**KIRKLEES METROPOLITAN COUNCIL
INVESTMENT & REGENERATION SERVICE**

DELEGATED DECISION TO DETERMINE PLANNING APPLICATIONS

Reference No:	2025/62/93521/E
Site Address:	20, Oxford Drive, Gomersal, Cleckheaton, BD19 4TU
Description:	Erection of two storey side extension
Recommending Officer:	Jennifer Booth

DECISION - REFUSE

CLIENT Josh Thompson 20 Oxford Drive, Gomersal, BD19 4TU	DATE 14/12/25
PROJECT Two Storey Side Extension	SCALE Varies @ A1
DRAWING Prop. Plans & Elevs.	PROJECT NUMBER 2512
REV A	SHT 02

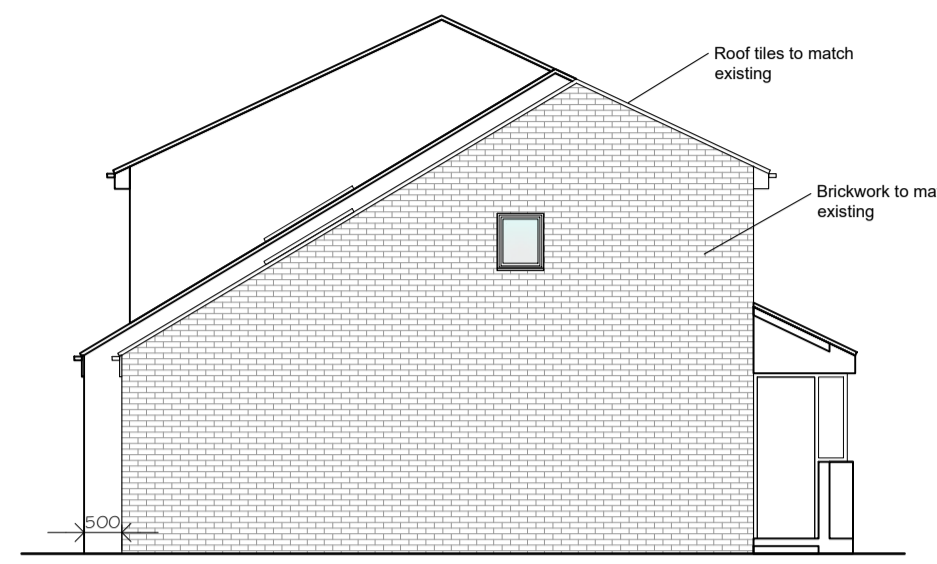
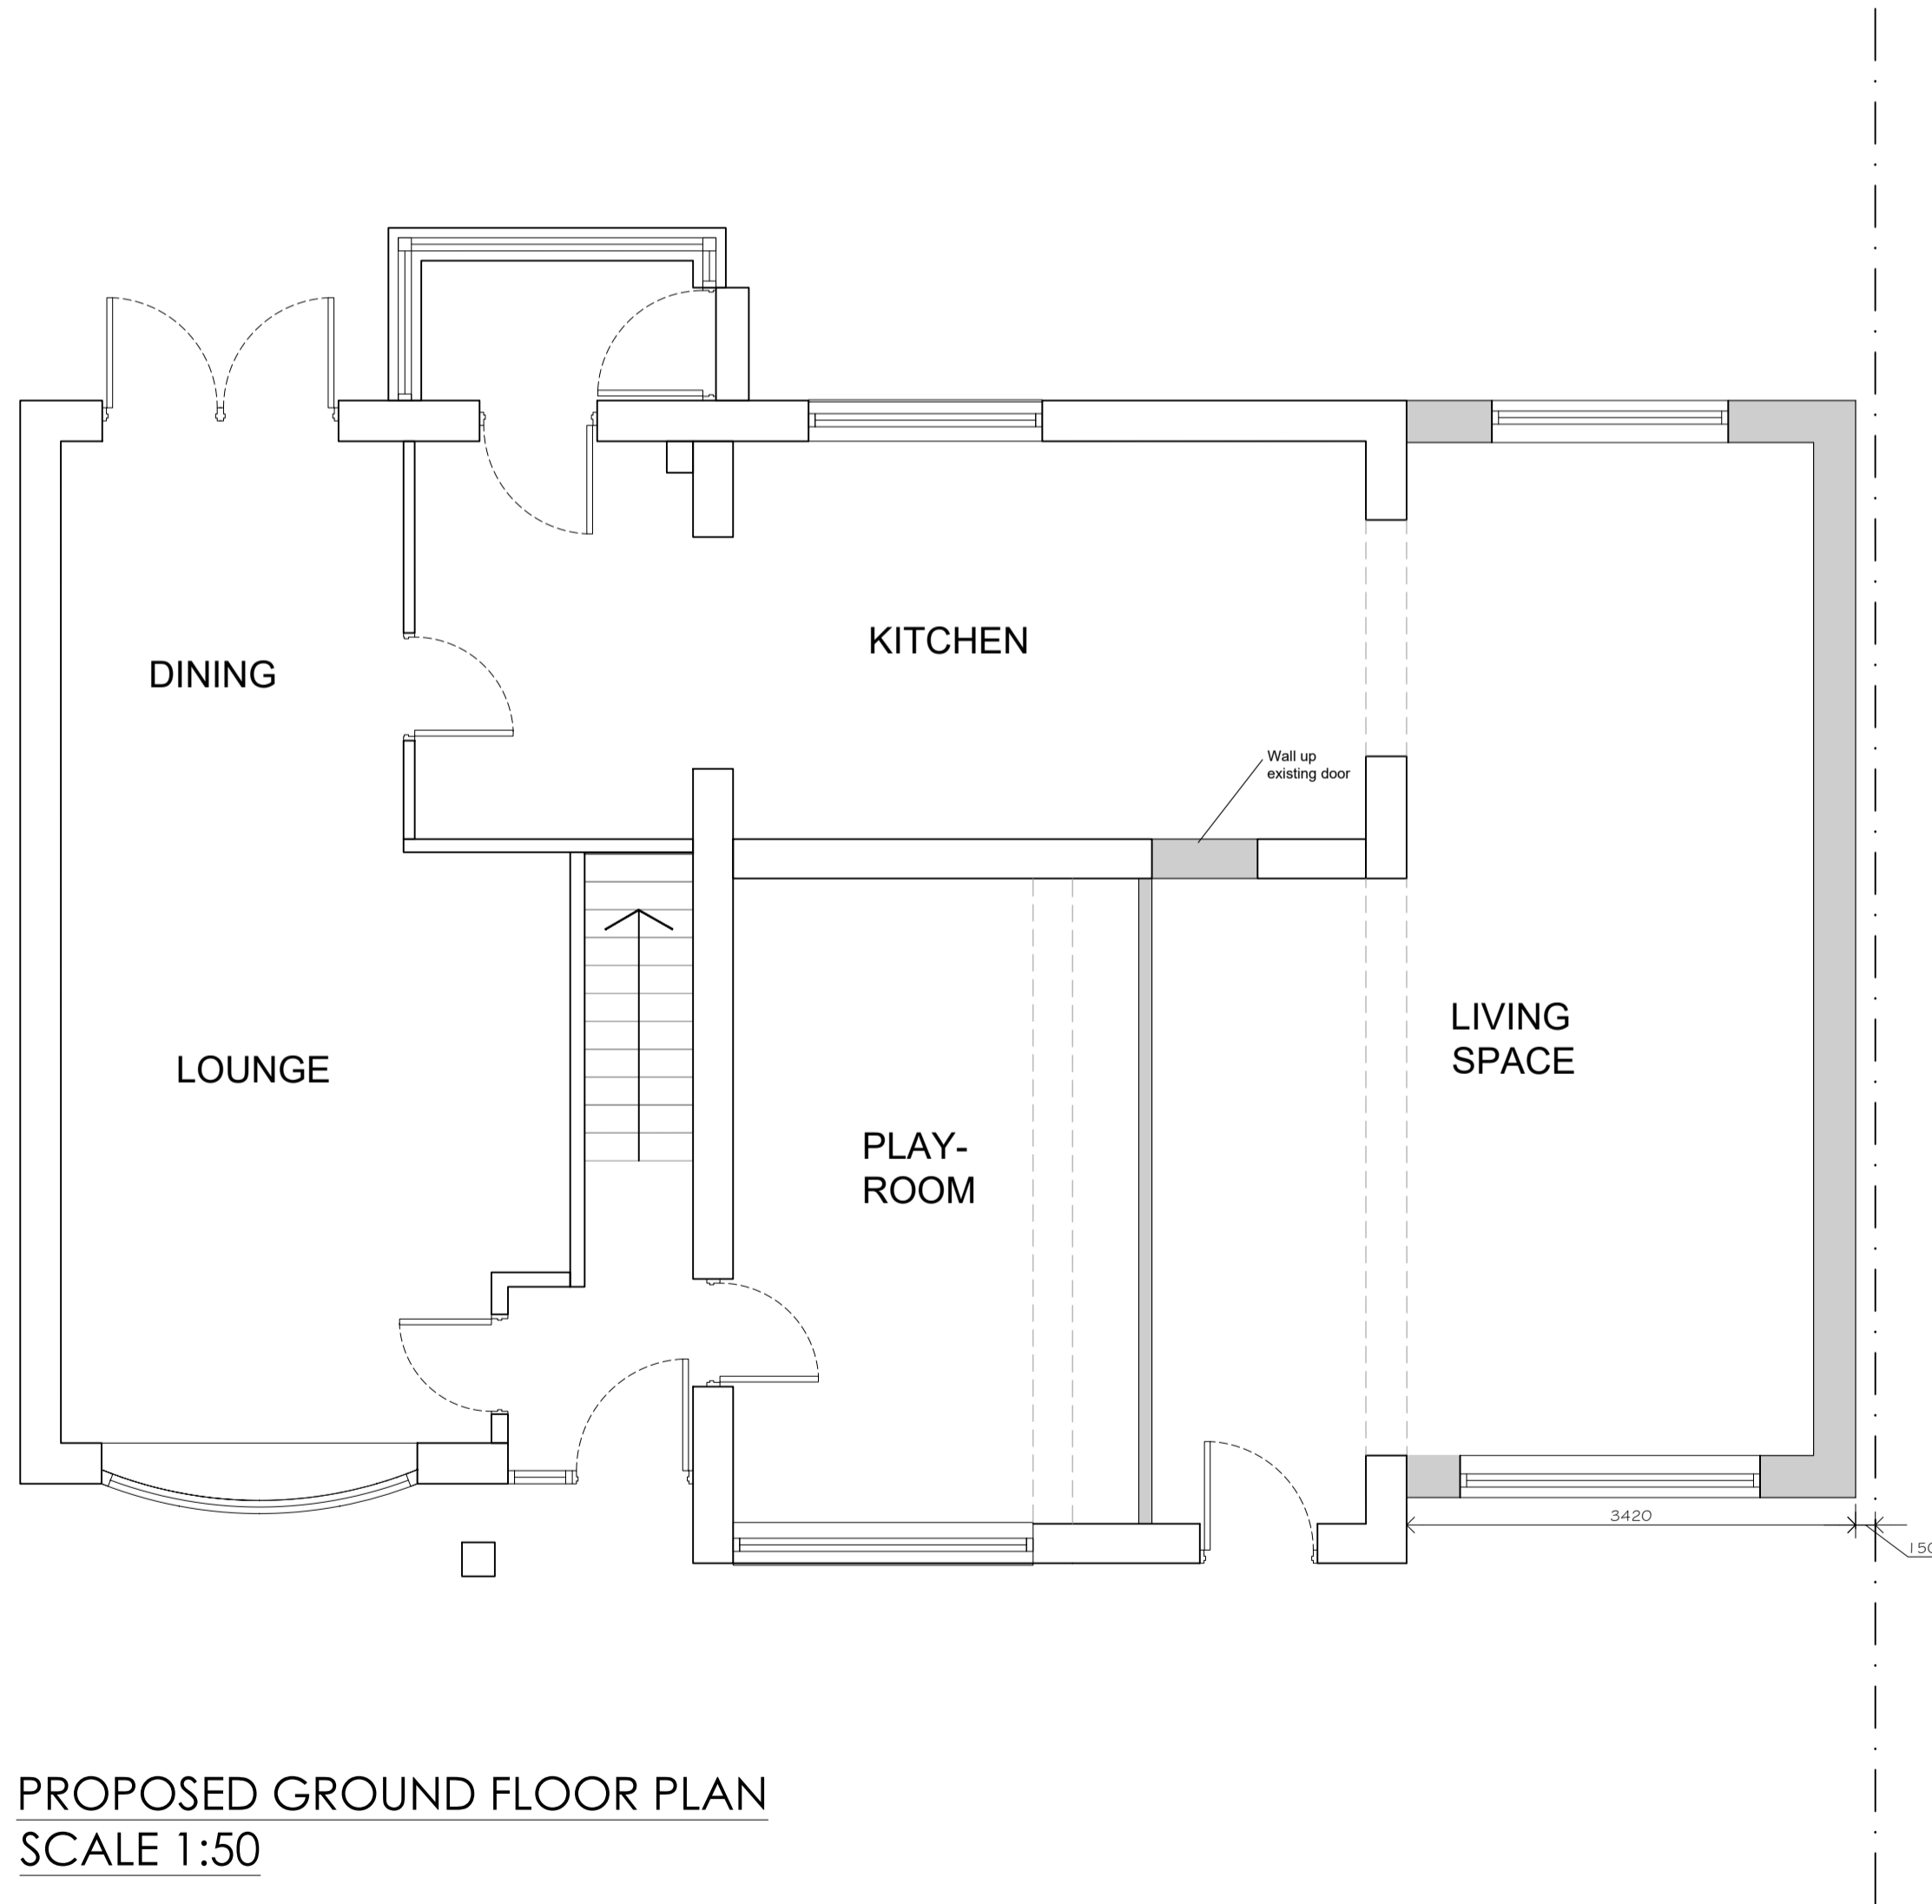
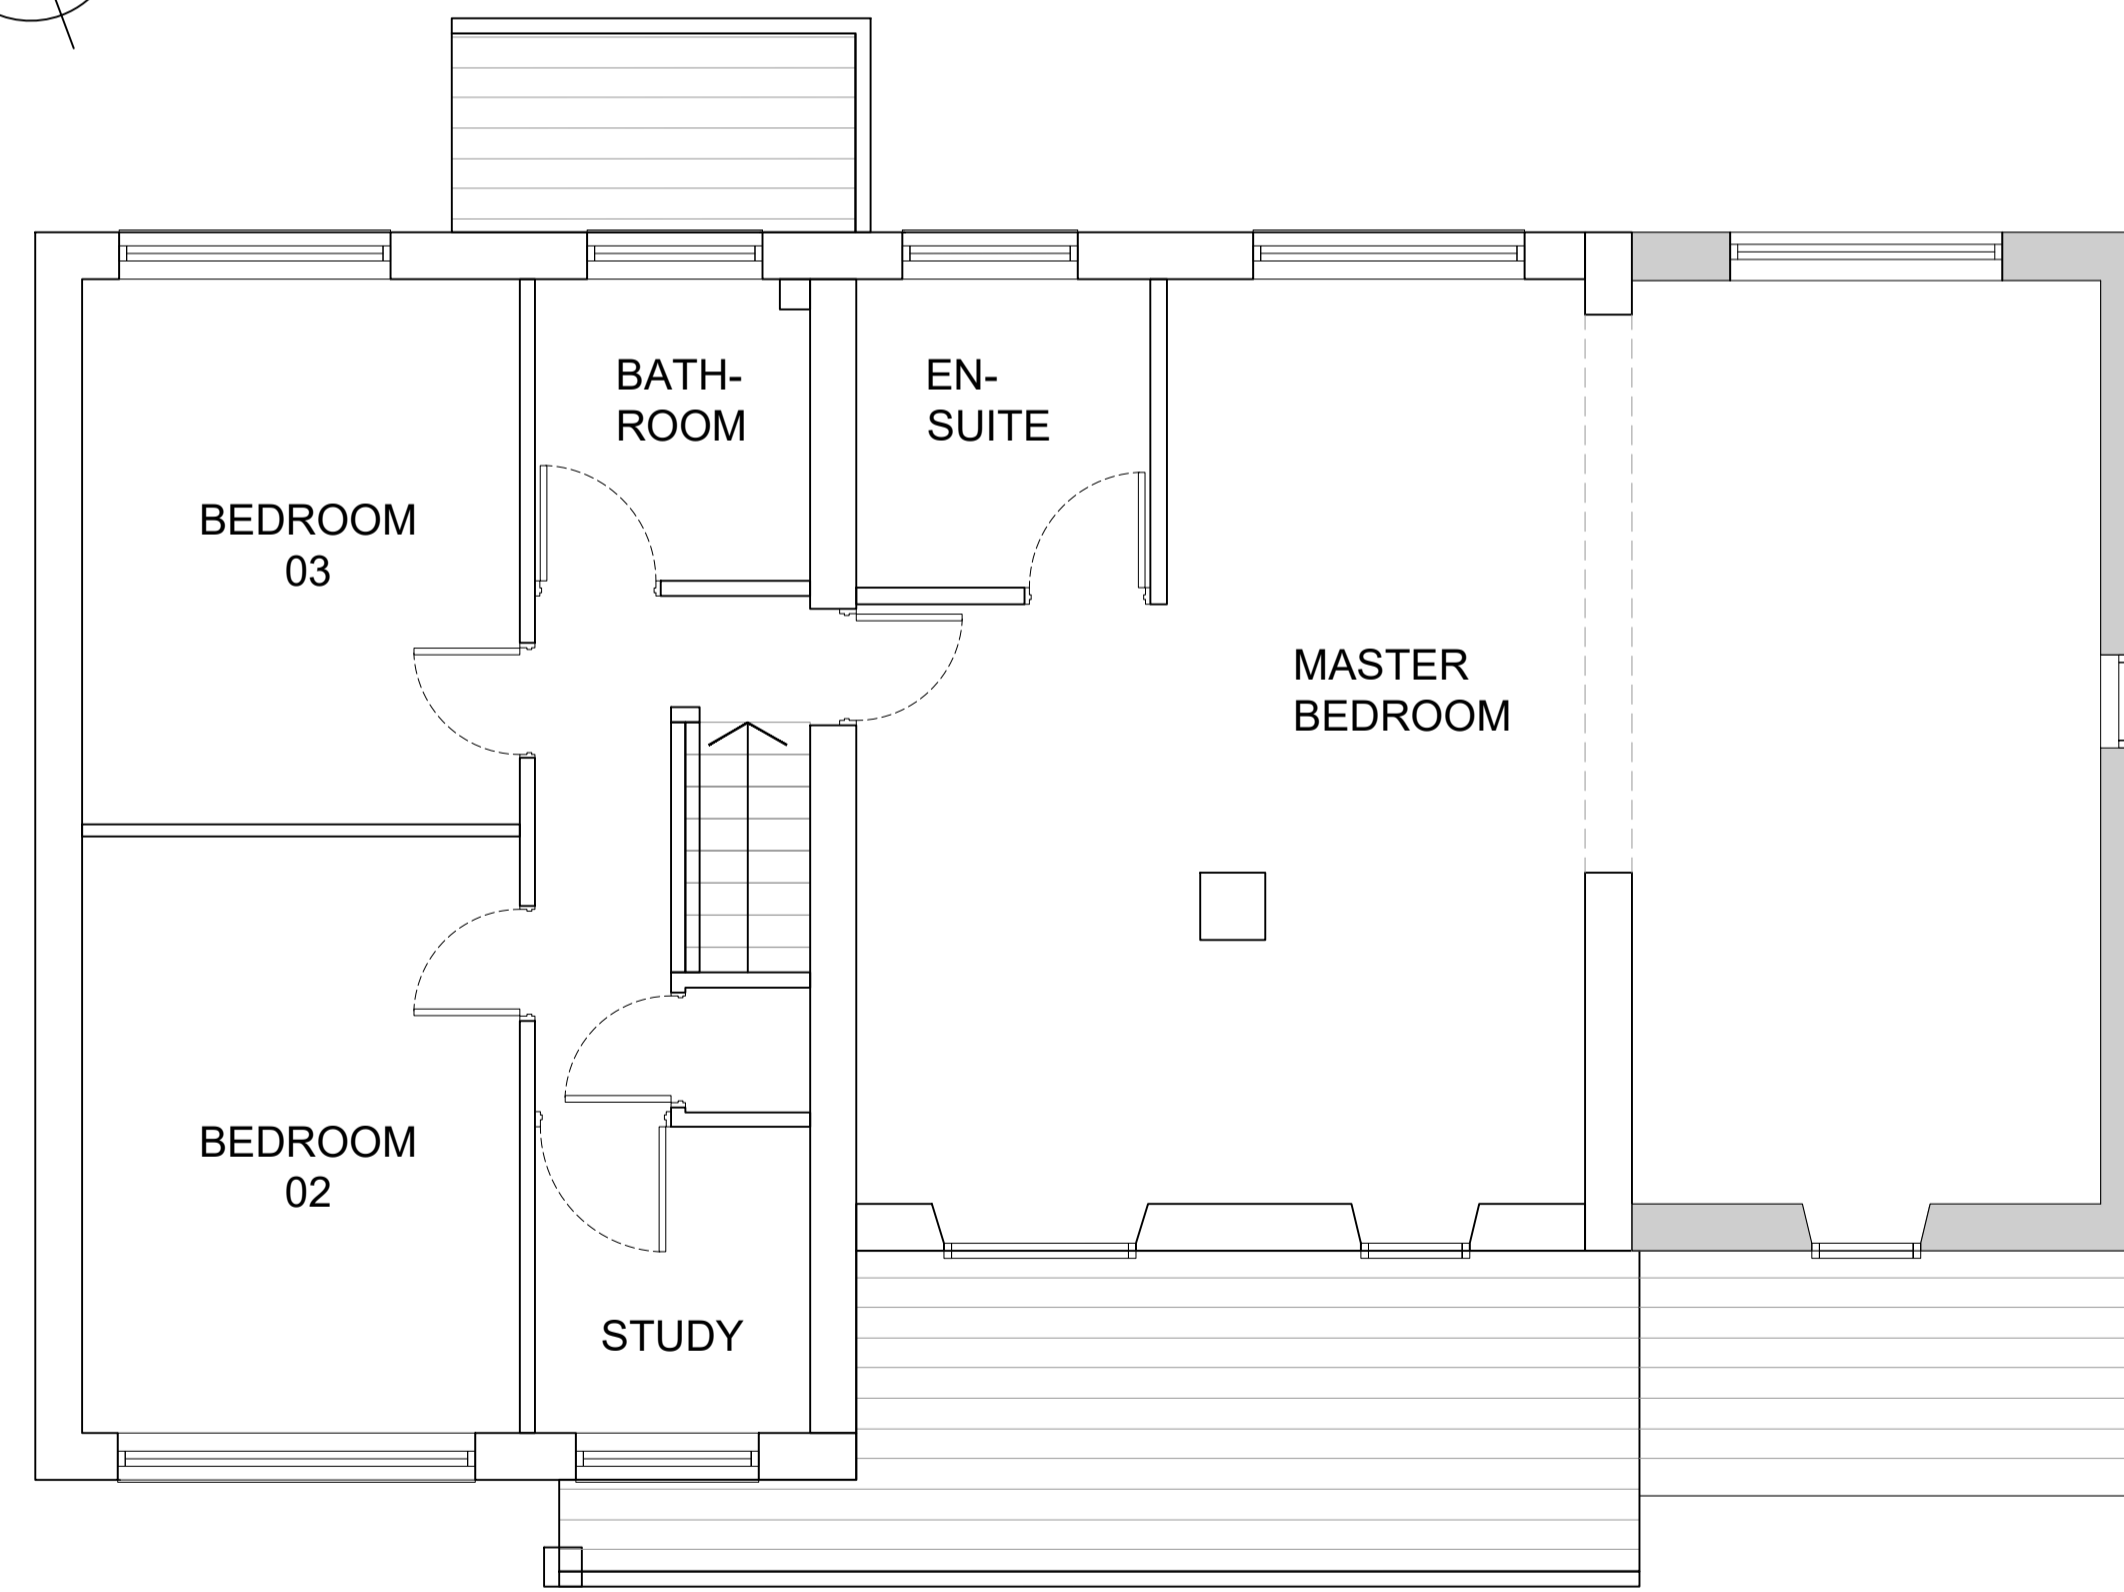
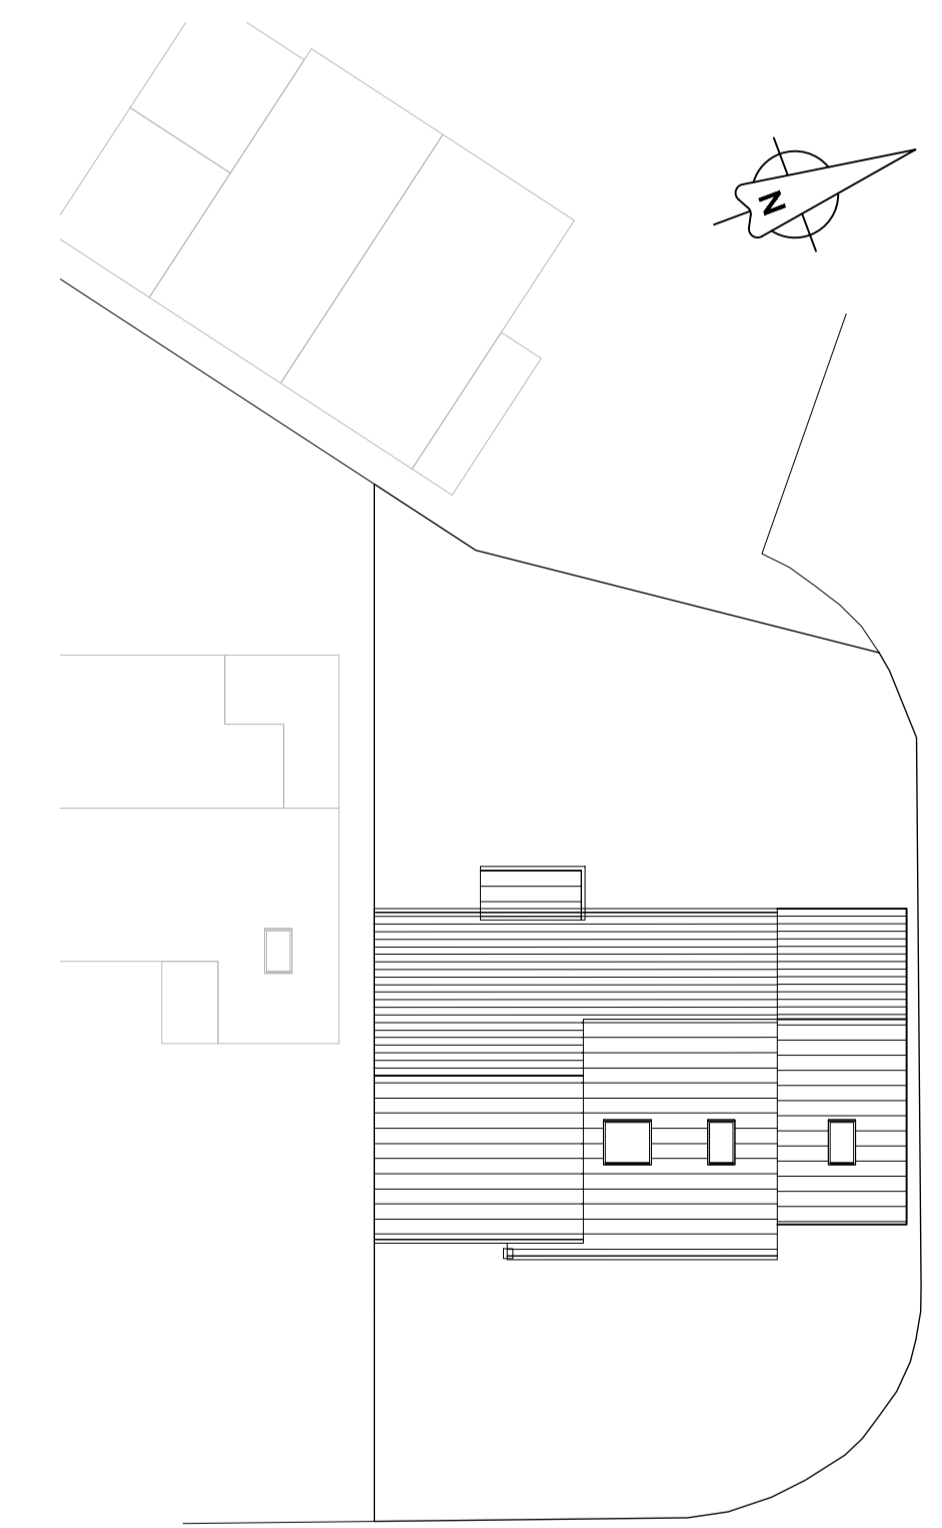
The proposed side extension would present as a single-storey addition with a steeply pitched roof when viewed from the front but would read as a two-storey structure from the rear due to design of the property. The dwelling has already been extended to the side, with permission granted in 1979, resulting in an elongated form on a prominent corner plot. Further increasing

the width of the property in this highly visible location would create an appearance that is incongruous and out of keeping with the established character of the area. Whilst it is acknowledged that the proposed materials would match the existing dwelling, this would not sufficiently mitigate concerns regarding the design, scale, and overall visual impact of the development.

Having taken the above into account, the proposals would result in significant harm to the visual amenity of both the host dwelling and the wider street scene. The extension, by virtue of its form, scale and layout, would create an incongruous and visually intrusive addition in a prominent location, which would not appear subservient to the existing building. As such, the development fails to comply with Policy LP24 of the Kirklees Local Plan in respect of good design, conflicts with KDP 1 & 2 of the House Extensions & Alterations SPD, and does not accord with the aims of Chapter 12 of the National Planning Policy Framework, which seeks to ensure development is sympathetic to local character.

1. The proposed side extension, by reason of its form, scale and layout in a highly prominent corner position, would result in an incongruous and visually intrusive addition that would cause harm to the visual amenity of both the host dwelling and the wider street scene. The development would not appear as a subservient or sympathetic addition and would fail to respect the established character of the area. To permit the proposal would be contrary to Policy LP24 of the Kirklees Local Plan, Key Design Principles 1 and 2 of the House Extensions & Alterations SPD, and the aims of Chapter 12 of the National Planning Policy Framework.
